26 February 2013

**Submission re SSD 5356 Hornsby Hospital Redevelopment Stage 1**

Appendix 1

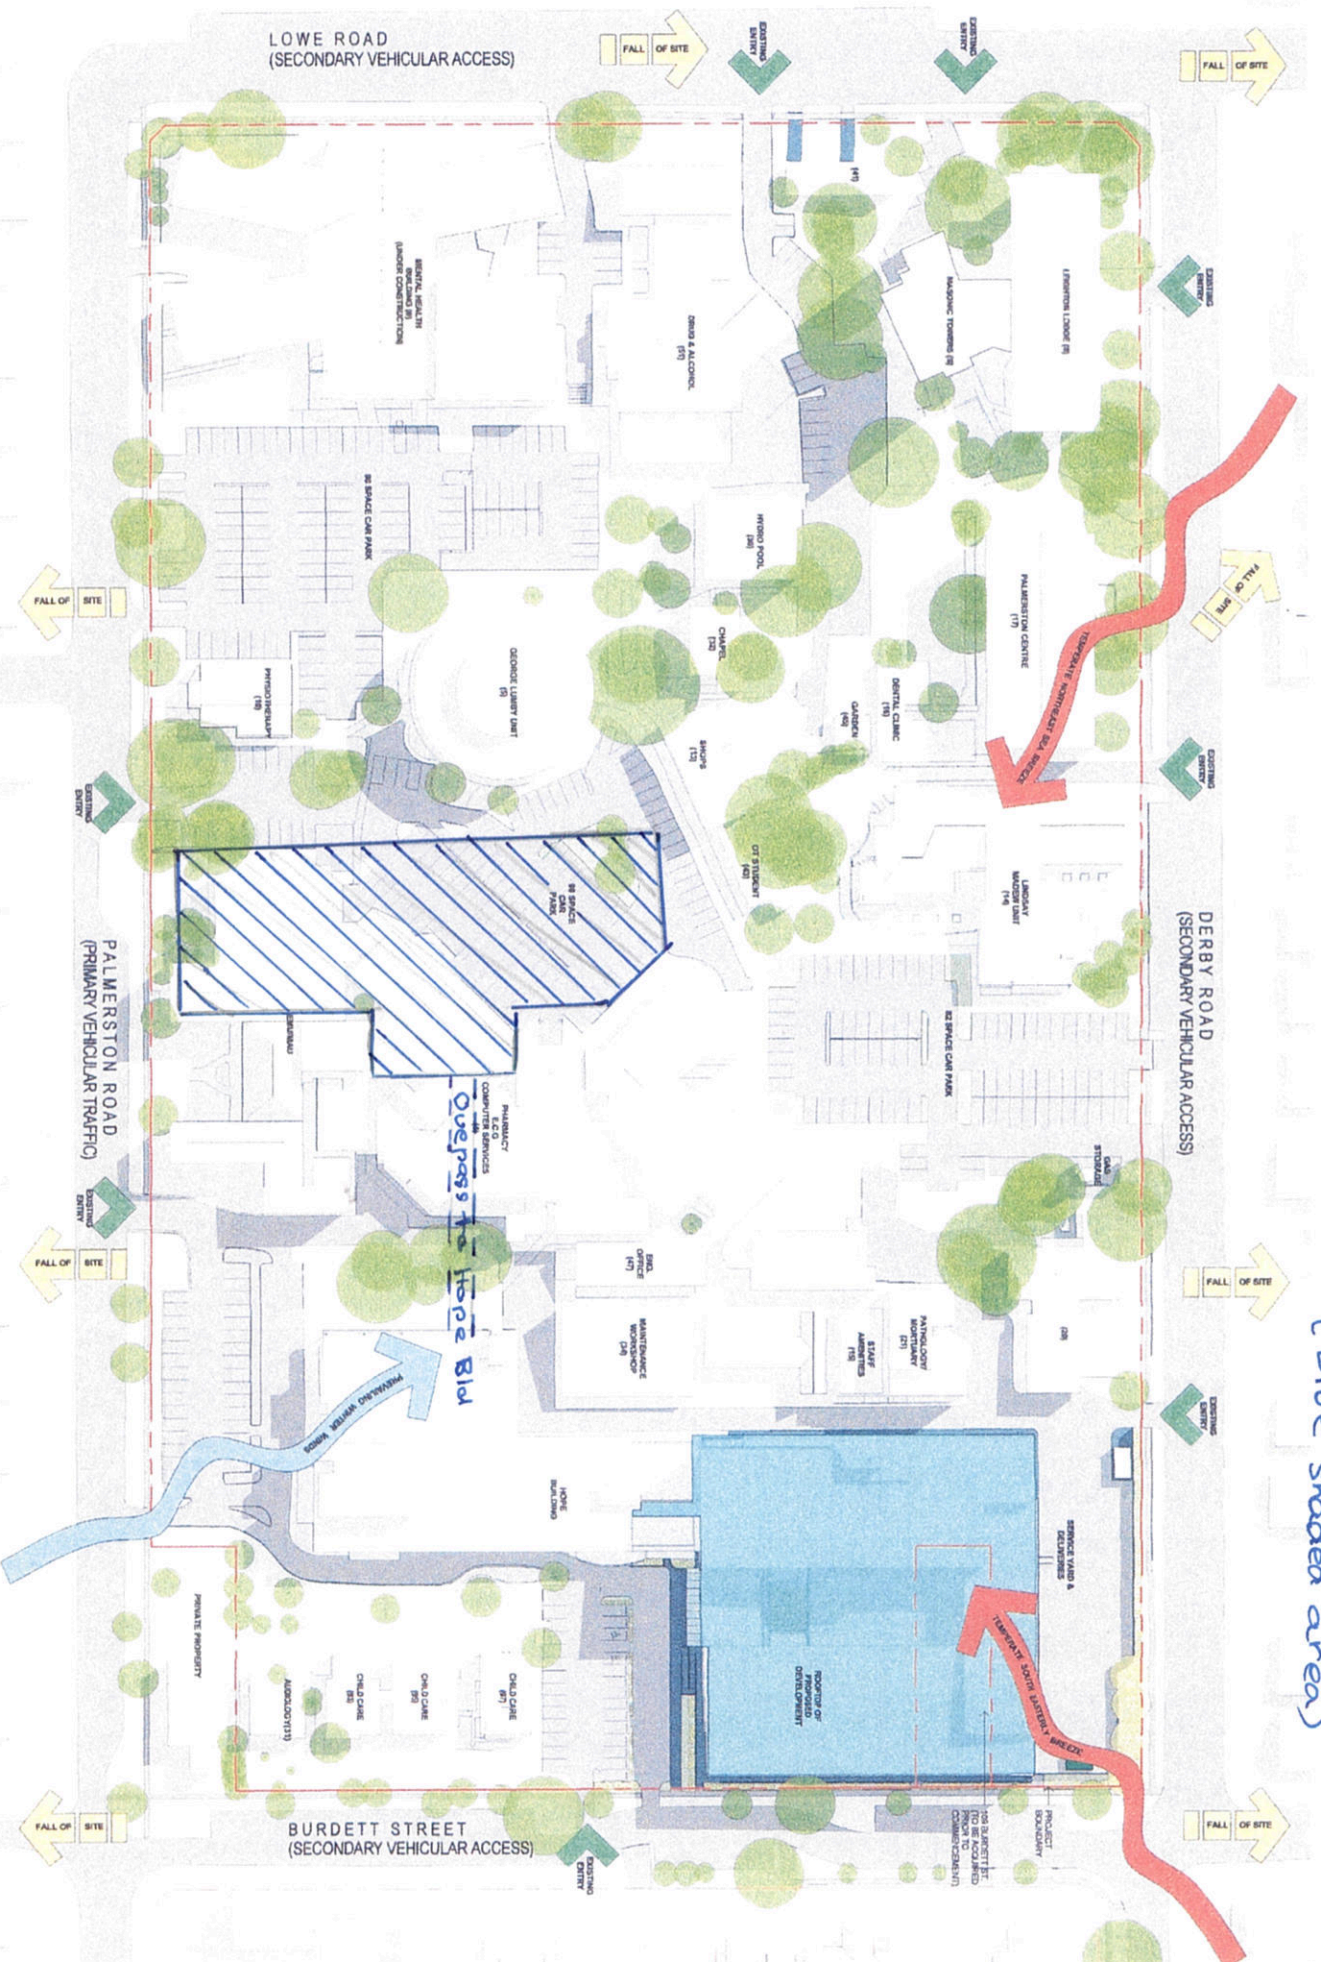
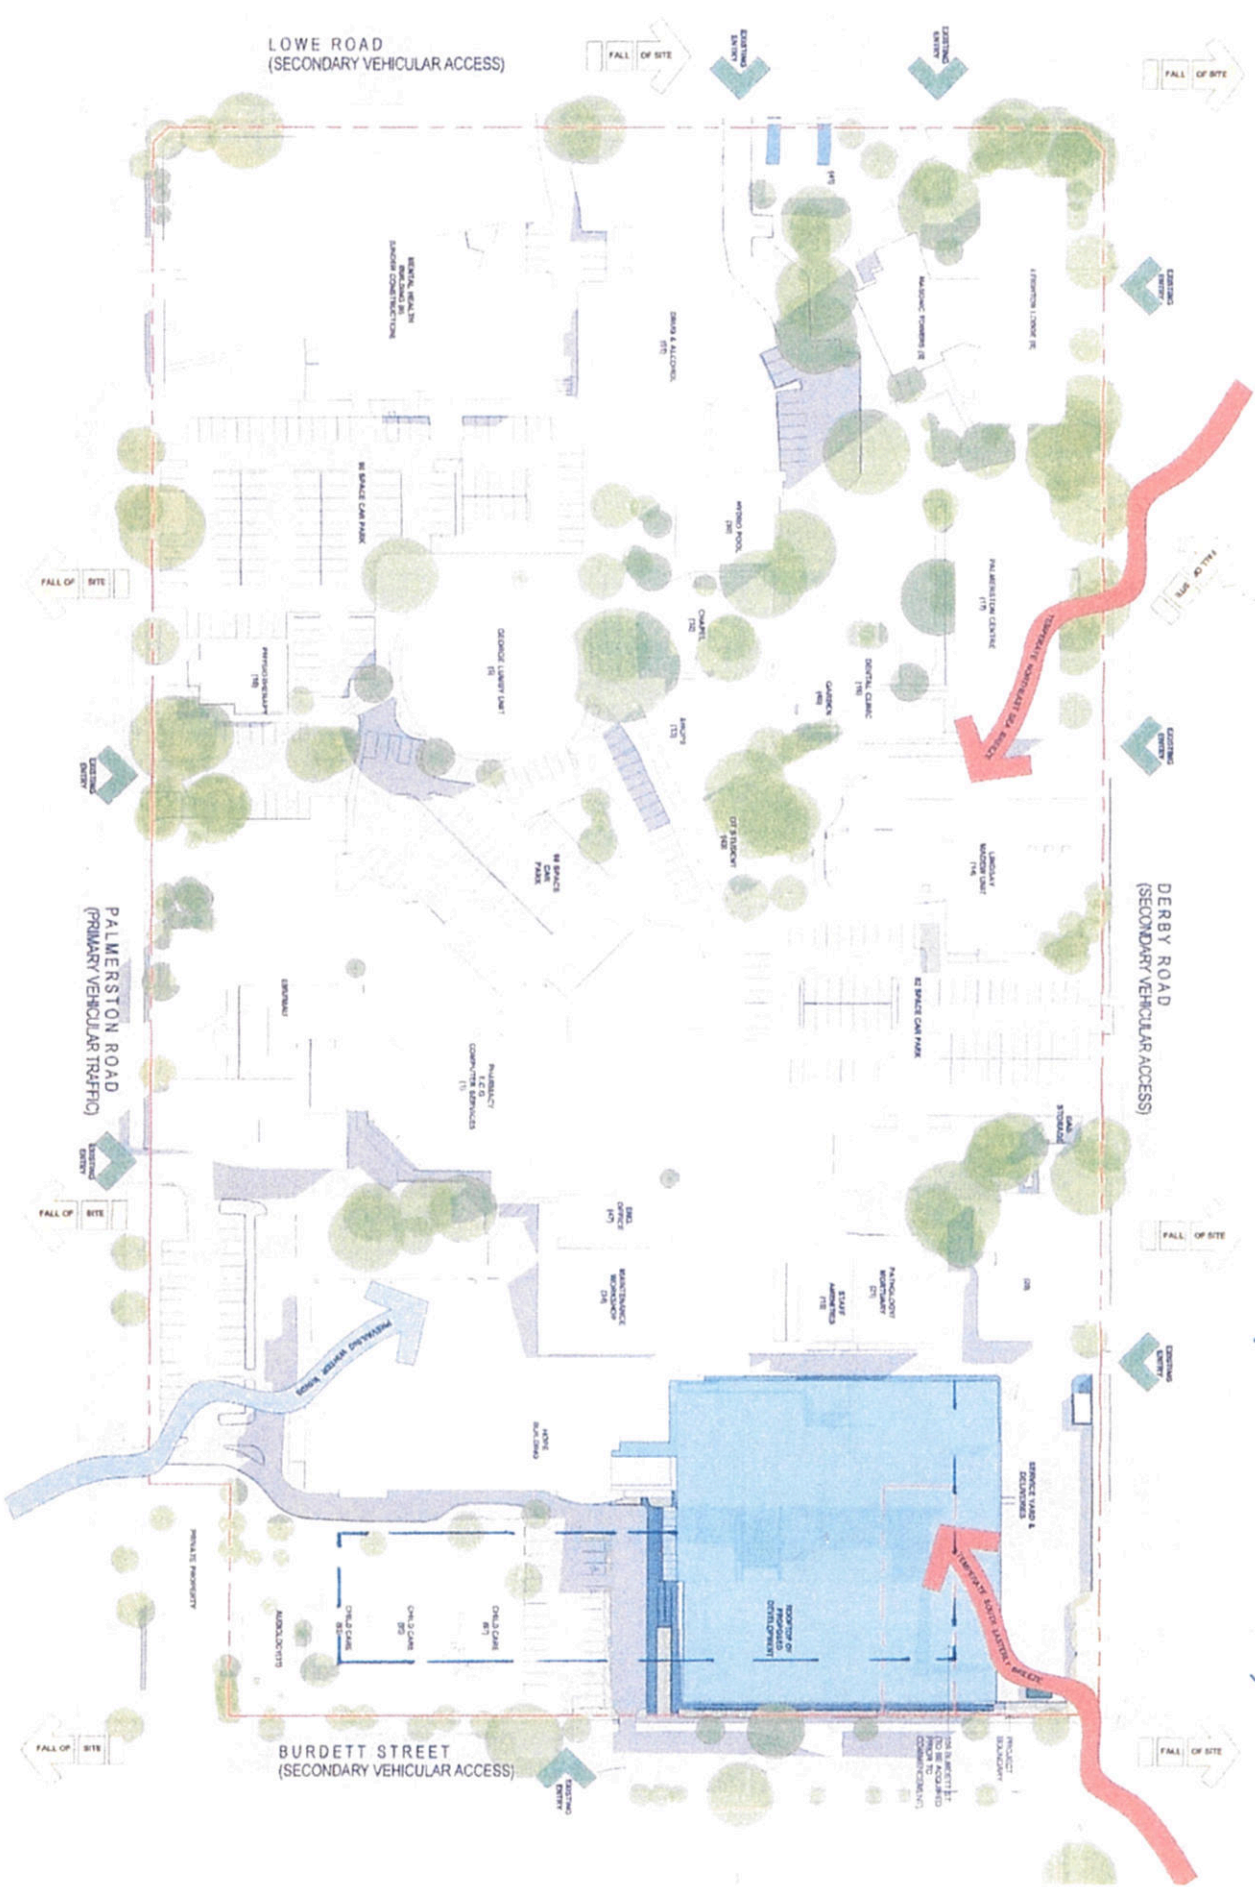
The proposed setback of 2.5 metres from Burdett Street does not respect the street setbacks established throughout the surrounding residential area, which generally are in the order of eight to ten metres, and the overscaling will be exacerbated by this proposed forward alignment. There is insufficient modelling of the built form, little articulation, and no transitional element to ameliorate the excessive overscaling and the excessive height.

2. The Burdett Street setback should be increased to a minimum of 10 metres to respond to the characteristic alignments of the surrounding residential area and to provide a landscape setting that is an integral part of the established character of the area. This setback will also decrease the dense overshadowing of Burdett Street.

Appendix 4

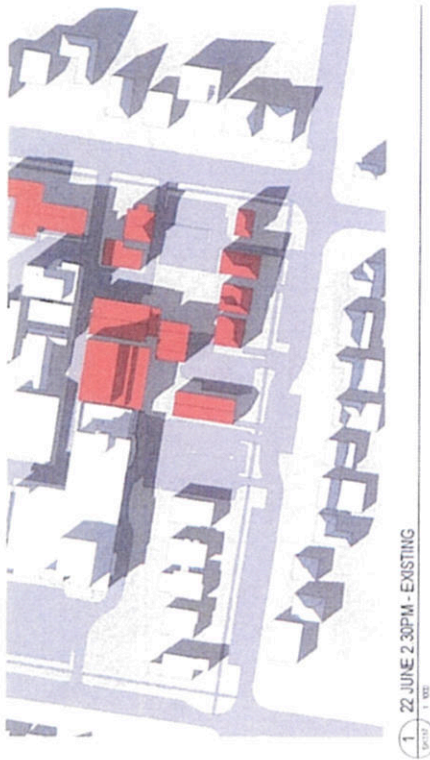
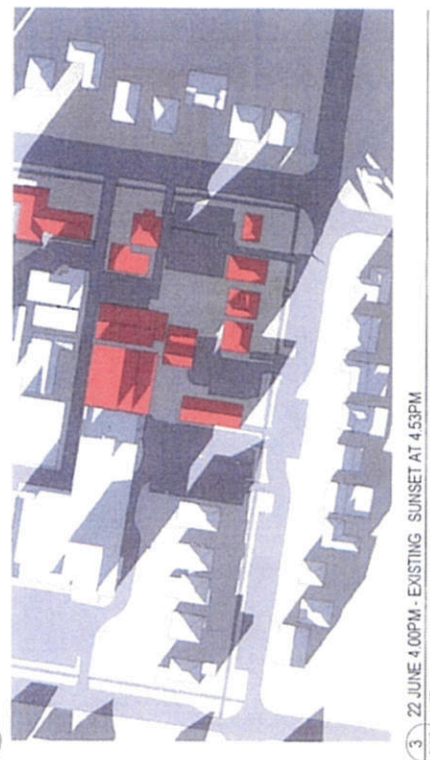
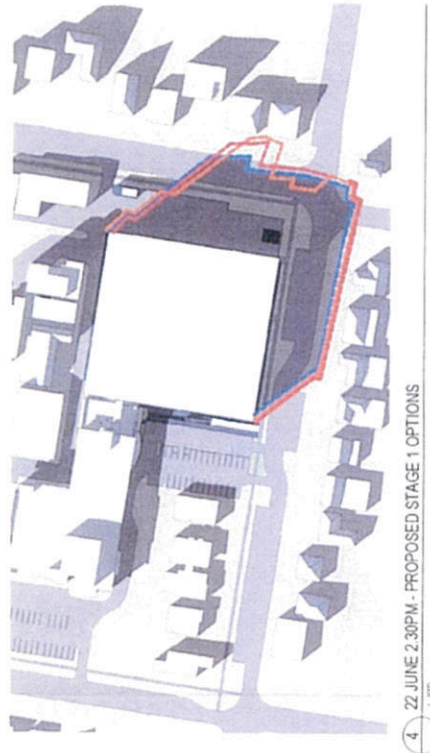
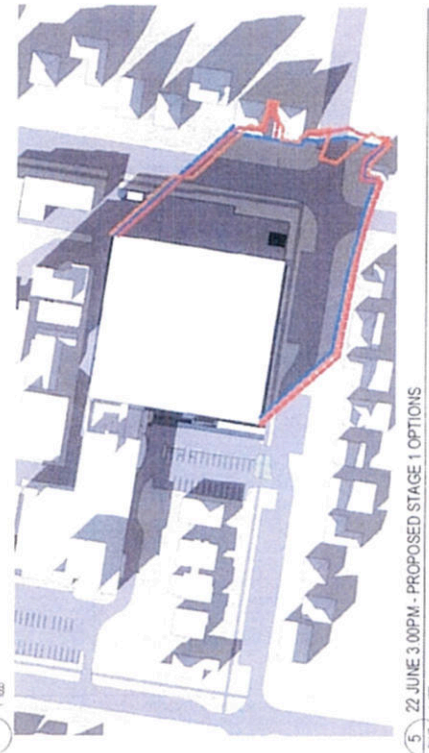
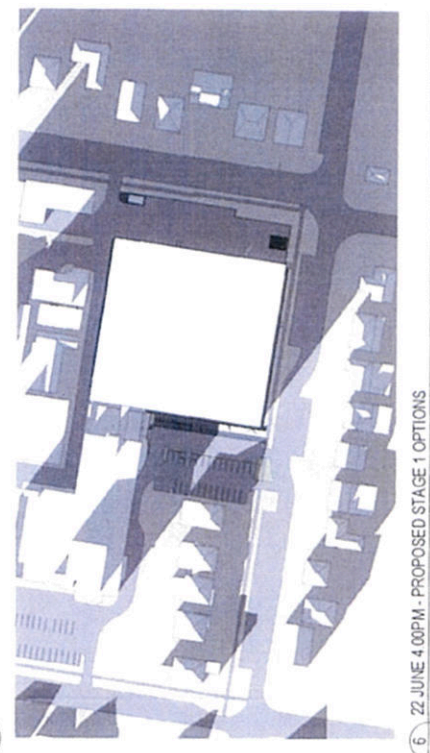
The proposal does not fulfil DGR 4, in that it will result in the overshadowing of Burdett Street throughout the winter months, creating a dense solid shade and gloomy street character. Such solid shadow is inconsistent with the character of the surrounding area, where any shading cast from trees is dappled.
